From: [REDACTED]
Sent: 08 November 2018 10:10
To: Charlotte Bodin
Subject: RE: 36 Lime Avenue, Aldingbourne AL108/18/HH
Attachments: 36 Lime Avenue, Eastergate-DPA-01 rev03.pdf
Follow Up Flag: Follow up
Flag Status: Flagged

36 Lime Avenue, Aldingbourne AL108/18/HH

SITE PLAN  
SCALE 1:500

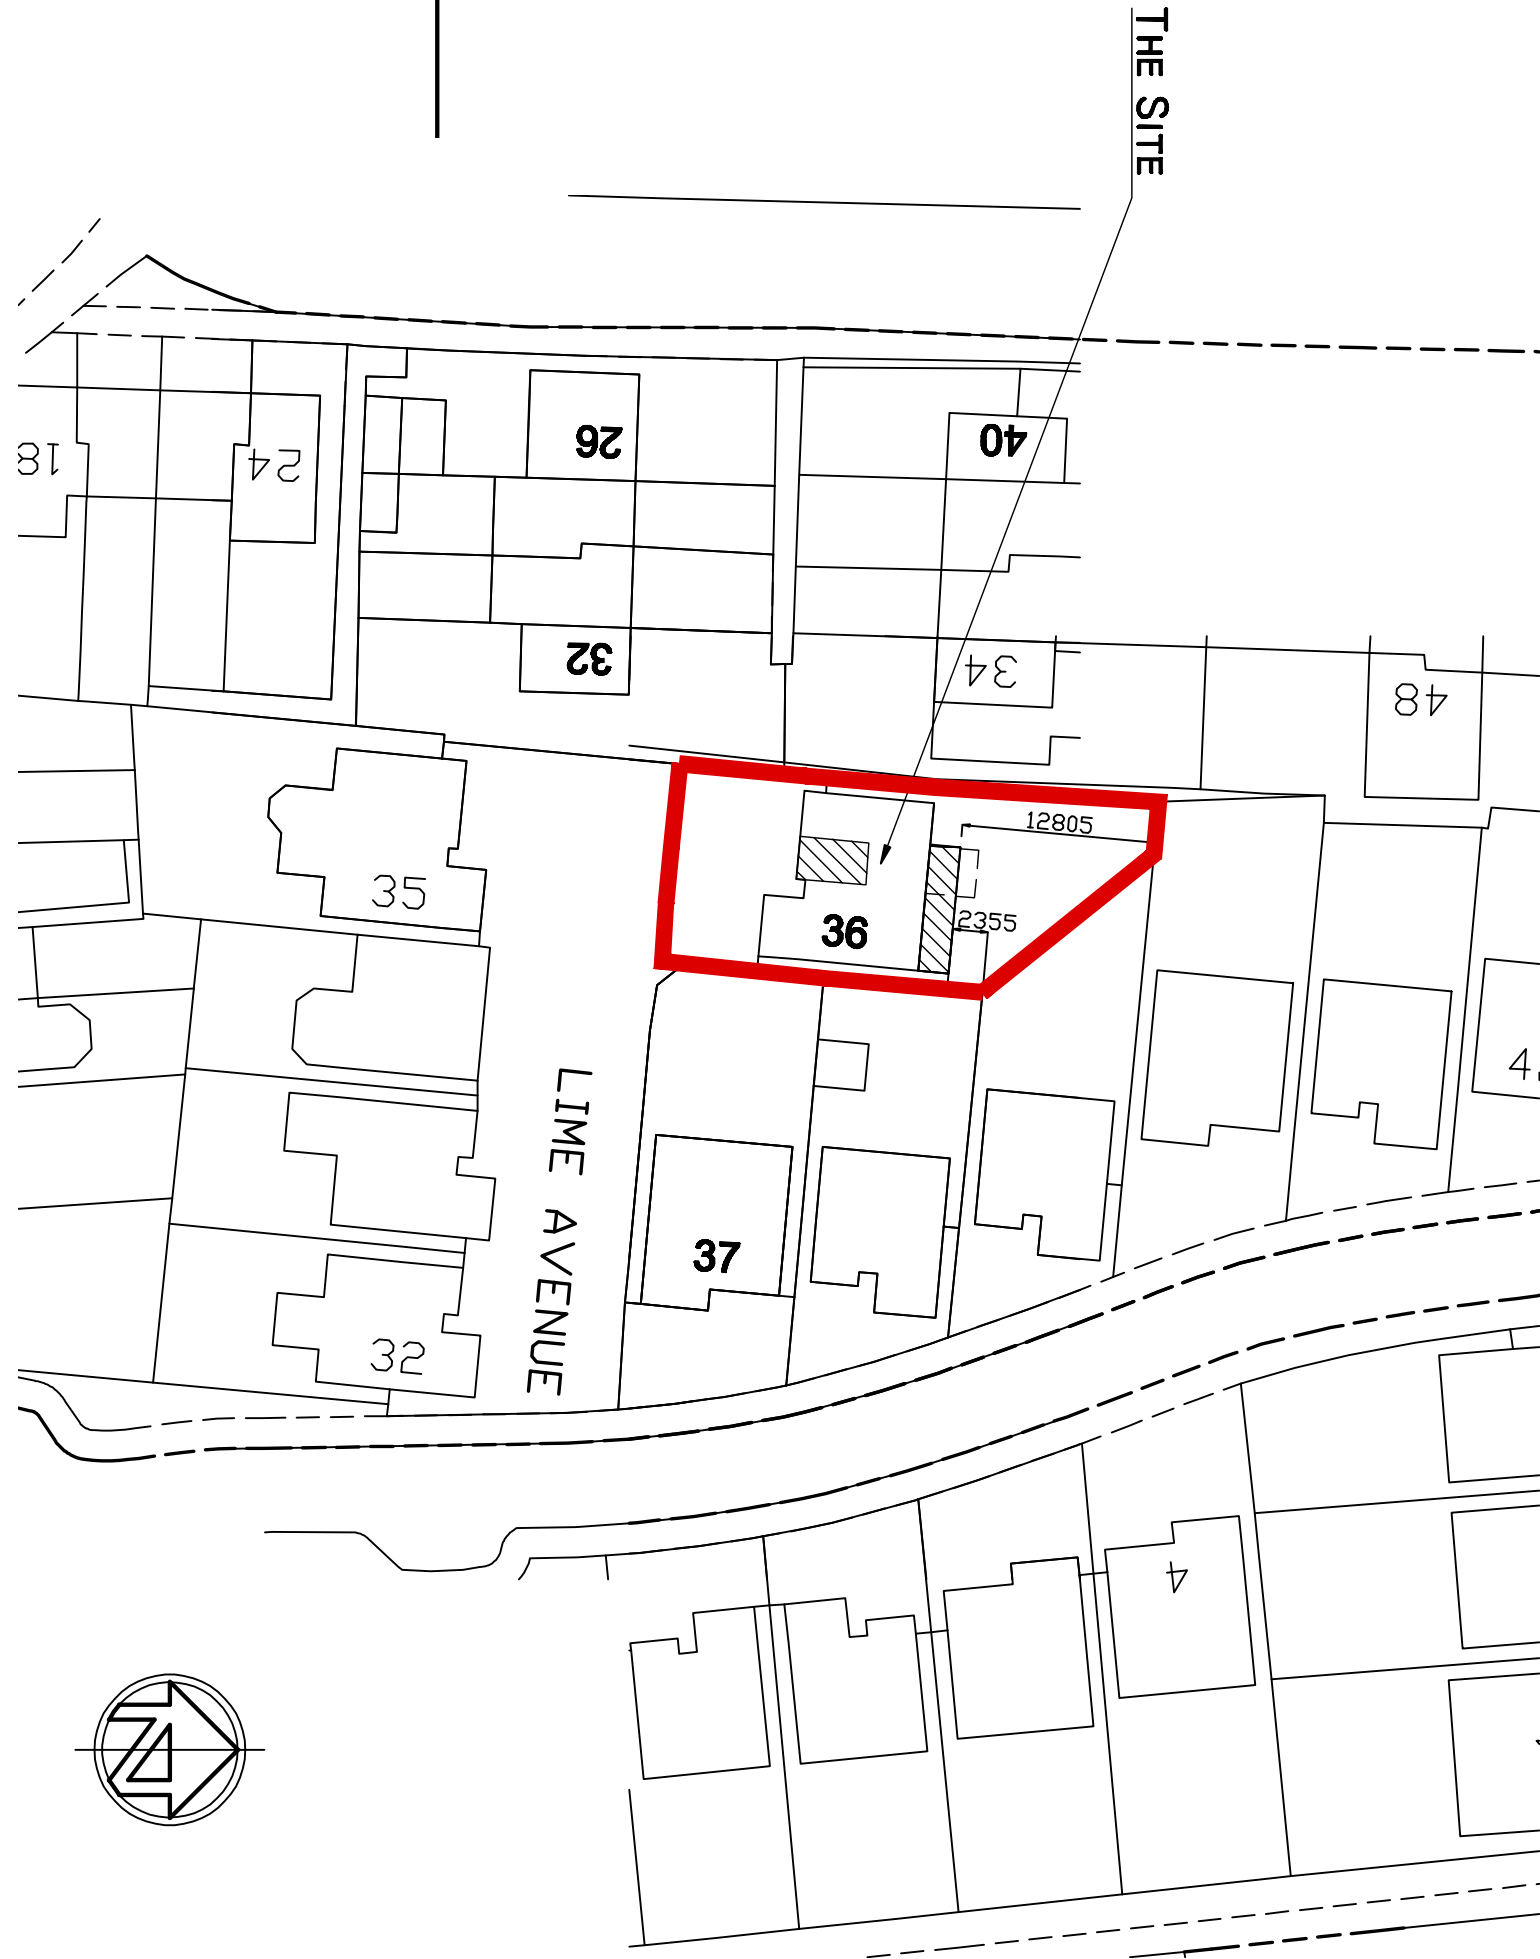
Thank you for your email. Please could you also add the dimension from the rear of the extension to the rear boundary?

Please see attached revised drawing previously emailed.

This shows the distance to the rear boundary on the site plan @ 1:500 scale.

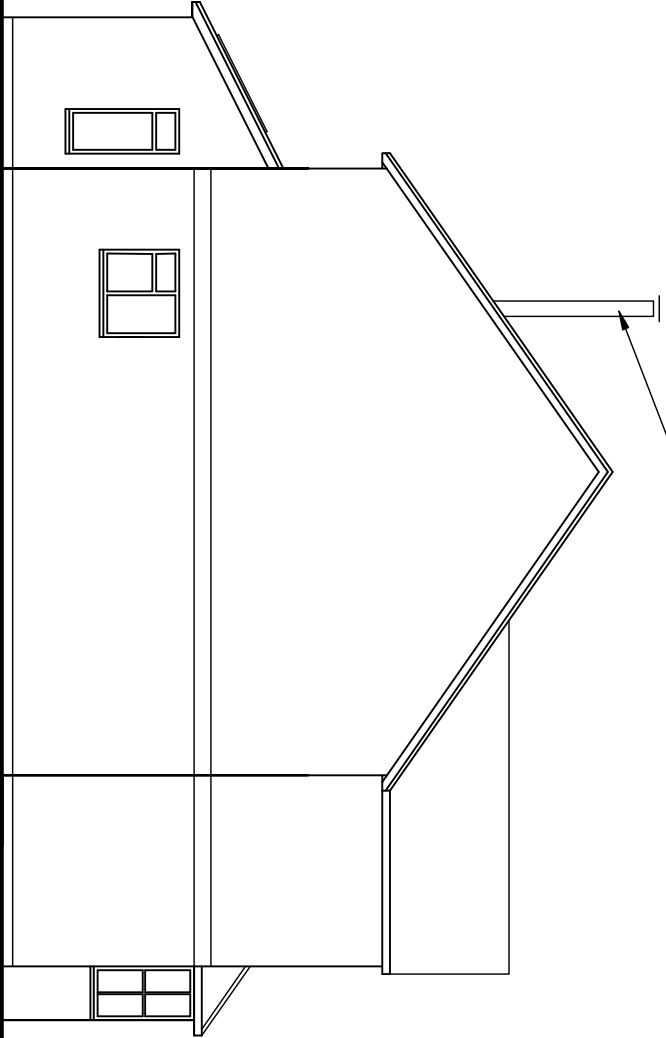
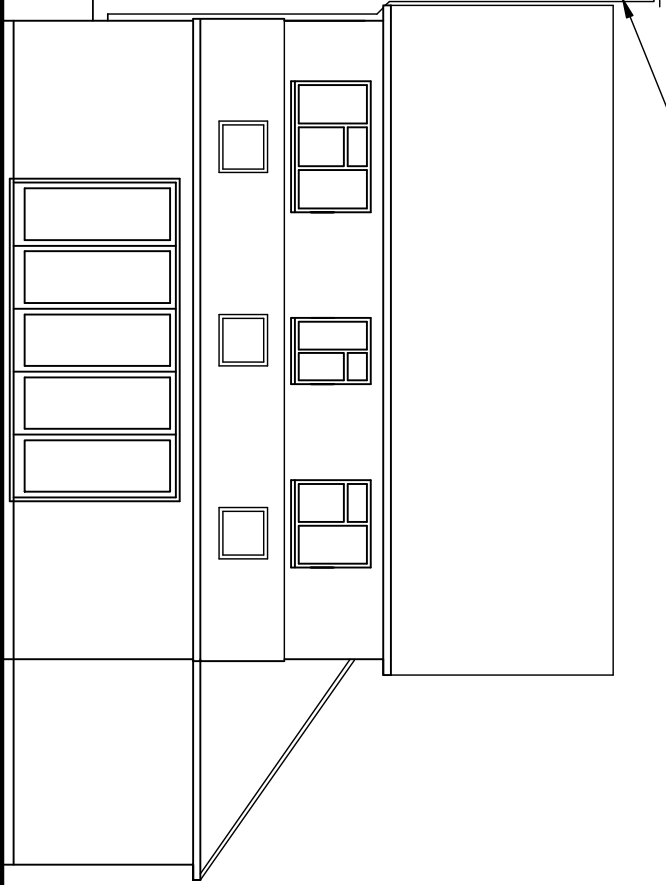
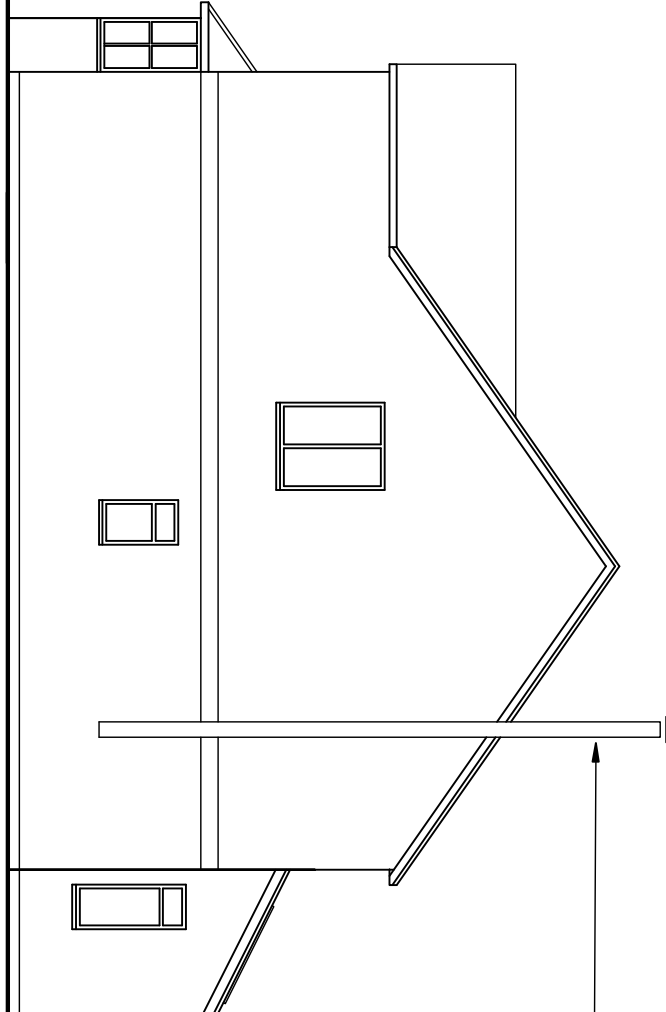
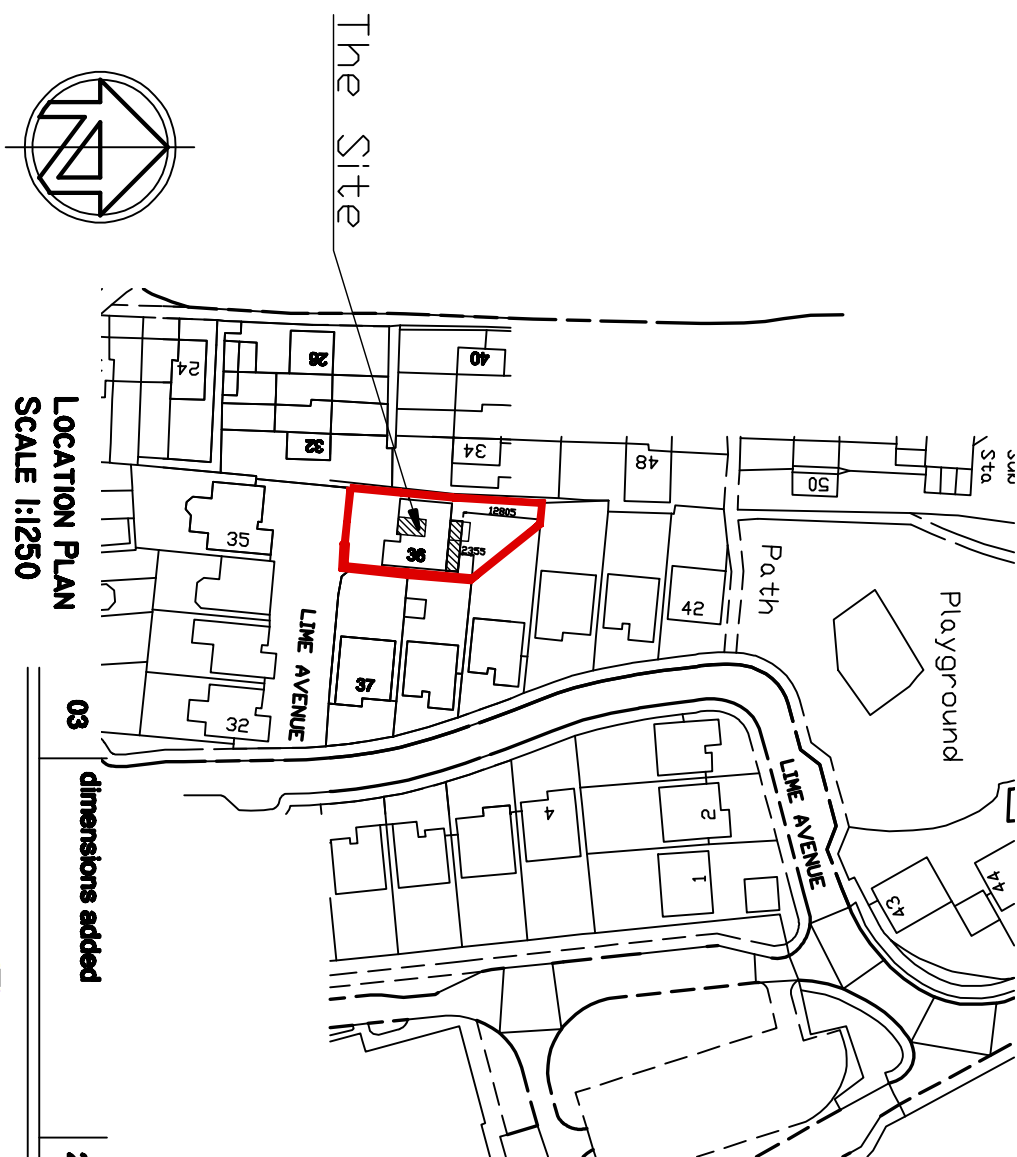
Please can I amend the current planning application to show a wood burning stove flue.

The wood burning stove flue is also shown on this drawing.
